Subject: Finley Battery Energy Storage System (BESS) (SSD-72430958)

ATTACHMENT A – RD Assessment Summary for Finley Battery Energy Storage System (SSD-72430958)

ATTACHMENT B – Detailed advice for Finley Battery Energy Storage System (SSD-72430958)

Figure 37:
Post-Development Scenario – Maximum
Flood Level, 1% AEP Event

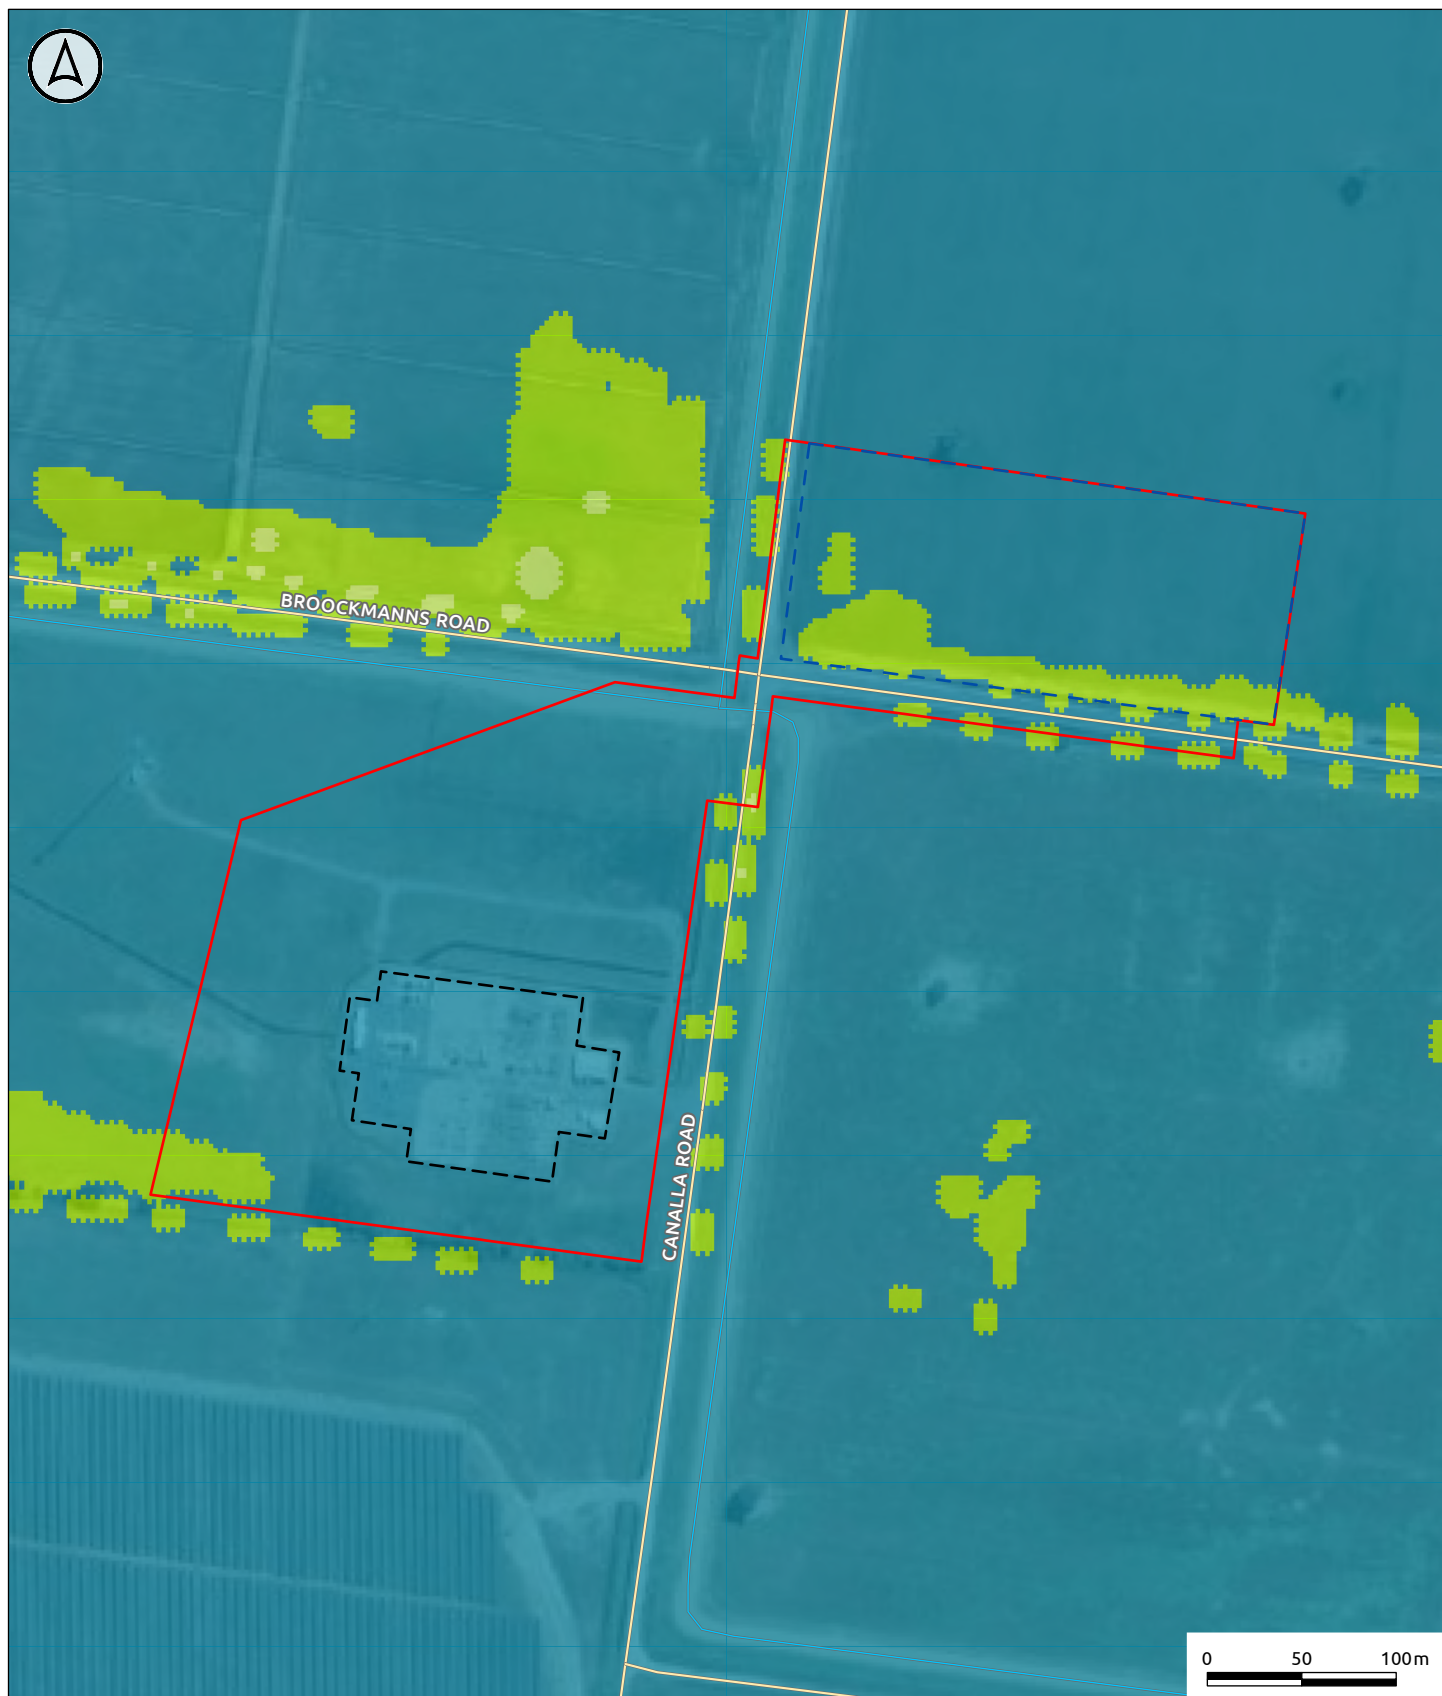
- 1.2. Utilise the 0.5% and 0.2% AEP events as proxies for assessing the impact of climate change.
2. The WIA needs to assess whether there will be detrimental increases in flood affectation of other properties and/or assets off-site

The WIA provides an assessment of the proposed site conditions on the 1% AEP flood event. The WIA includes afflux mapping which indicates that there is a slight (0.04 m) increase in flood levels to the northeast in the post-development scenario. RD notes that a dwelling and ancillary infrastructure is in proximity to the demonstrated afflux. The proponent should conduct further assessment, including assessing the additional design flood events, to accurately define the off-site impacts. Any identified detrimental increases in flood affectation to off-site properties and/or assets must be adequately mitigated.

- 2.1. Conduct further assessment to adequately define any detrimental increases in flood affectation of off-site properties and/or assets.
- 2.2. Where detrimental increases in flood affectation are identified the proponent should describe how the risk will be mitigated.
